11 November 2020

Our Ref: R/2016/41/B  
File No: 2020/492281  
Your Ref: SSD-7874

**Additional Response to Submissions – Harbourside Shopping Centre Redevelopment**

Image 31 Illustrative Scheme: Guardian Square

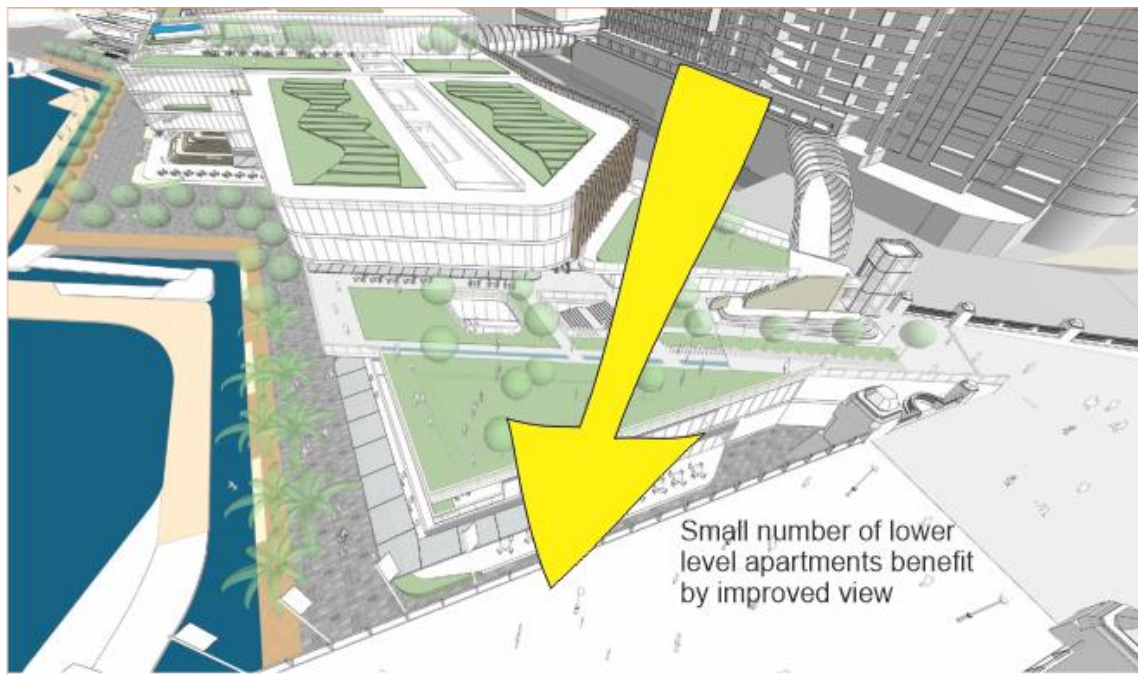
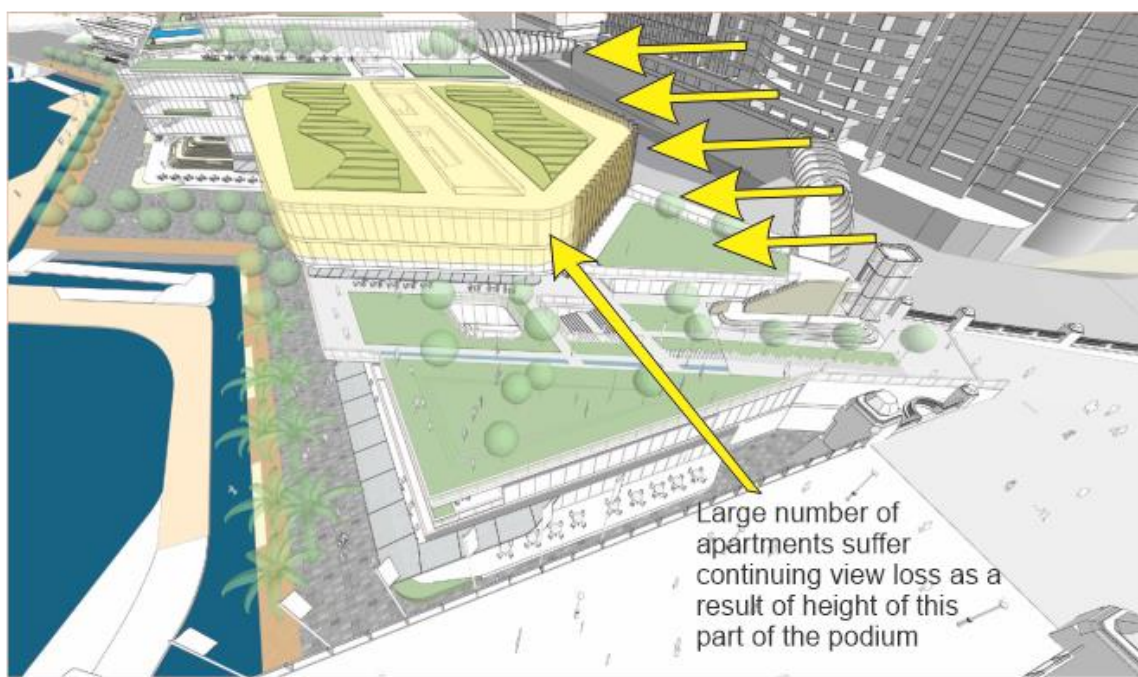
**c. Guardian Square**

The introduction of Guardian Square is a positive element. However, it is located over 2 levels, which do not relate to the surrounding existing public domain levels. One level (+17.6) appears to be aligned with the Murray Street bridge and the lower level (+13.75) with the existing levels at the western end of the Pyrmont Bridge.

The levels of the upper and lower levels of Guardian Square appear to be determined by the retail levels in the podium, connecting with the retail rather than seamlessly connecting with the adjacent public domain. A photomontage from the western end of the Pyrmont Bridge would be helpful in describing the relationship of Guardian Square with the Pyrmont and Murray Street Bridges as well as the levels relative to the existing structures. It may also inform if the alignment of the building is appropriate to the context, especially in relation to the heritage elements of the Pyrmont

However, more information is required for the levels and gradients as this is not clearly documented. The levels provided for the Murray Street bridge includes only the RL for the underside (+15.5) and for the top of the structure (+21.75). Assuming that the existing top of slab of the bridge is approximately 450-500mm above the underside, this results in a level for the existing bridge of approximately +16.0 and is 1.6m lower than the proposed upper level of Guardian Square.

The area between Murray Street and the Pyrmont Bridge is graded, It is not clear if at the interface of the Pyrmont Bridge and the site, if the RL is +13.75 at the lower level of Guardian Square. However, the photomontages show that the lower part of Guardian Square is approximately one storey higher than the Pyrmont Bridge with a ramp up to this level of +13.75.

There is a lack of equitable access demonstrated. There appears to be a lift at the end of the Murray Street Bridge in the photomontages and the indicative plan, but this is not shown in the building envelope drawings and it is not clear if this is a new or the existing lift. Stair access only will be limiting for those that are movement impaired or with prams and requires them to enter the shopping centre to access escalators and other lifts.

/ Axonometric view of the northern podium

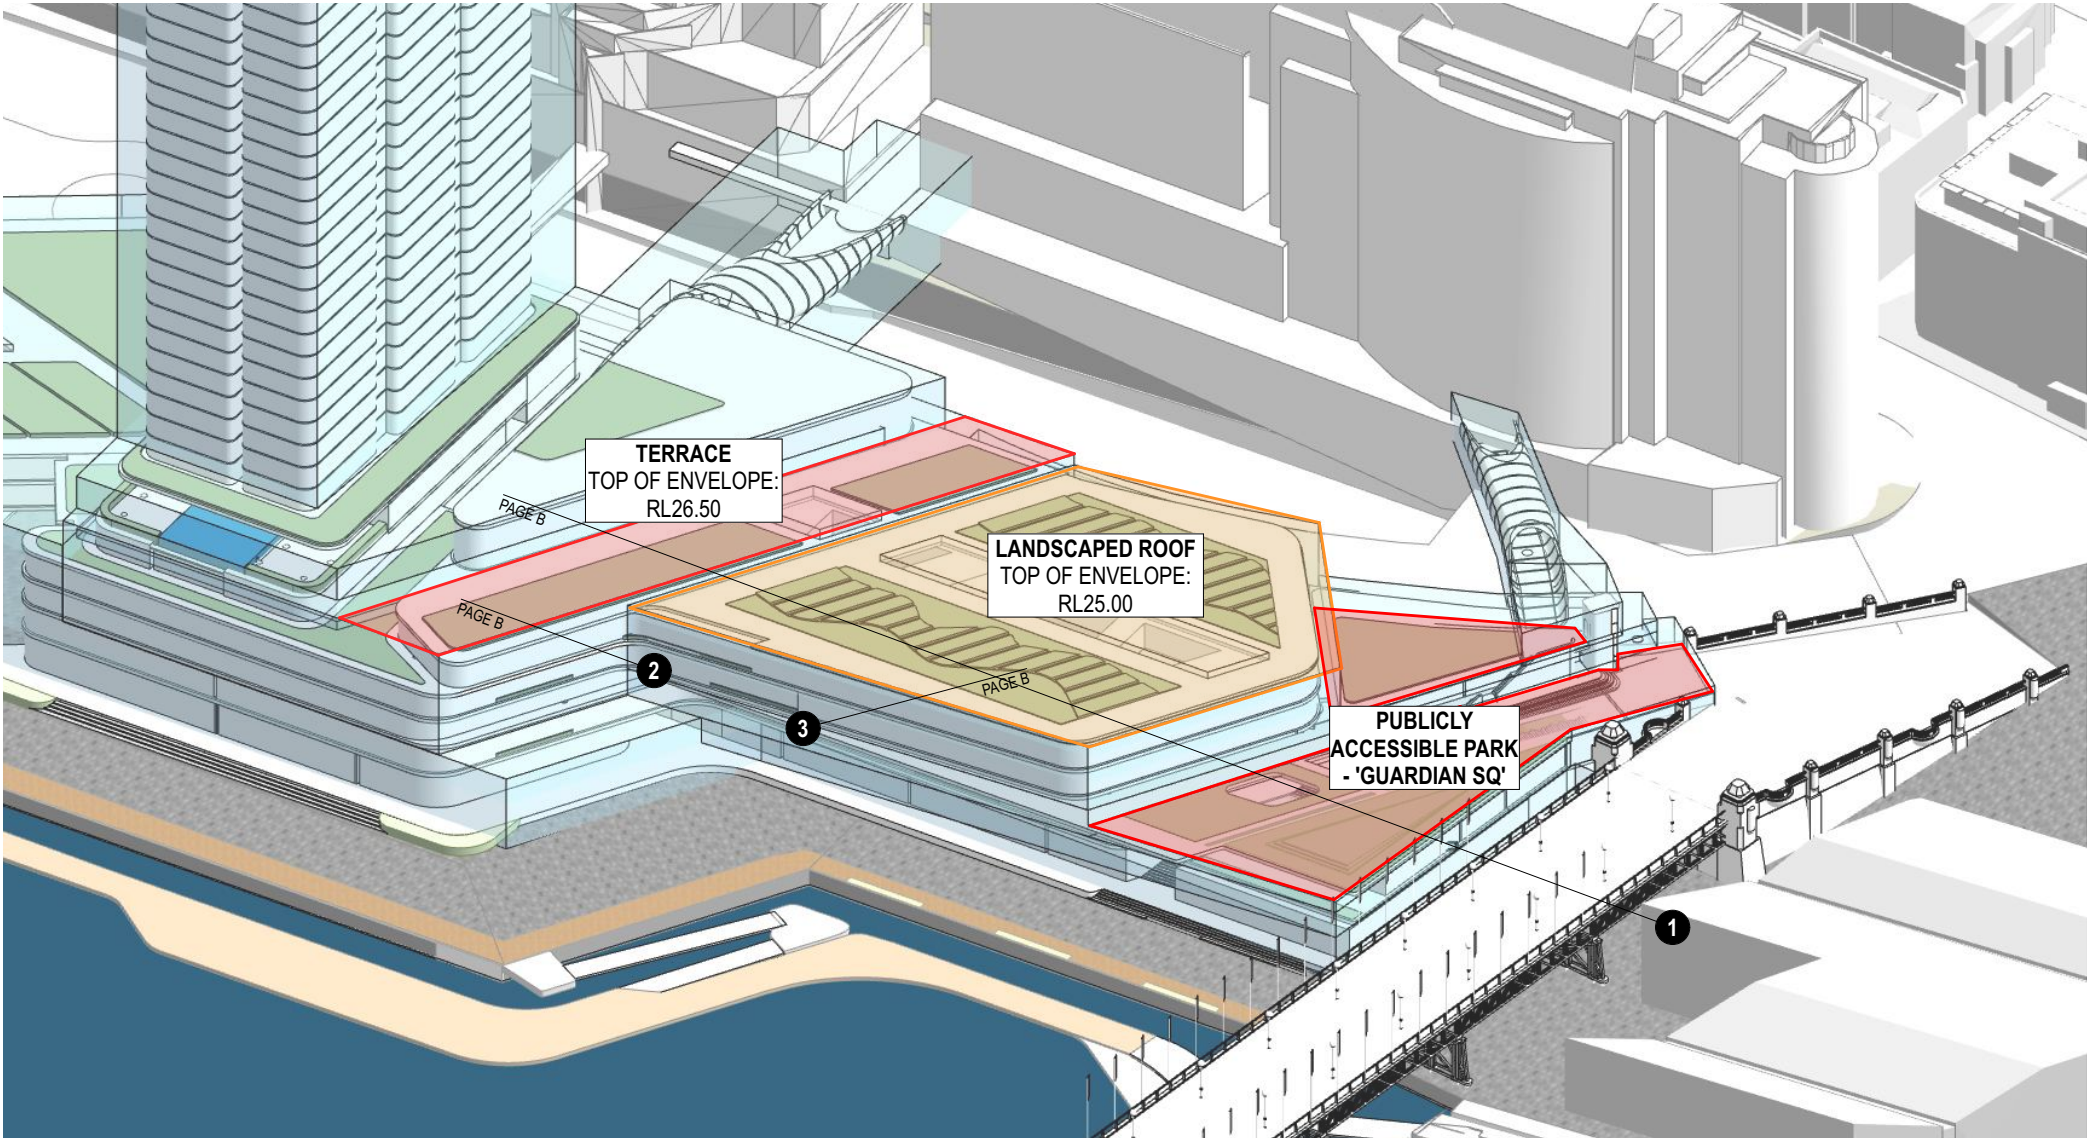
However, the amended envelope demonstrates a tiered podium to the north with varying levels of RL 25 and RL13.25. The RL 13.25 lower tier is still considered excessive and blocks sightlines from the Bridge. To enable clear site lines and uninterrupted views from the west, the lower tier is recommended to be further reduced to be no higher than the Bridge surface, at approximately RL 11.5.

Further, to improve the relationship of the development with surrounding buildings, the north-east corner of the podium should replicate the slanted building alignment of the Maritime Museum so as to increase the openness of the underbridge public open space.
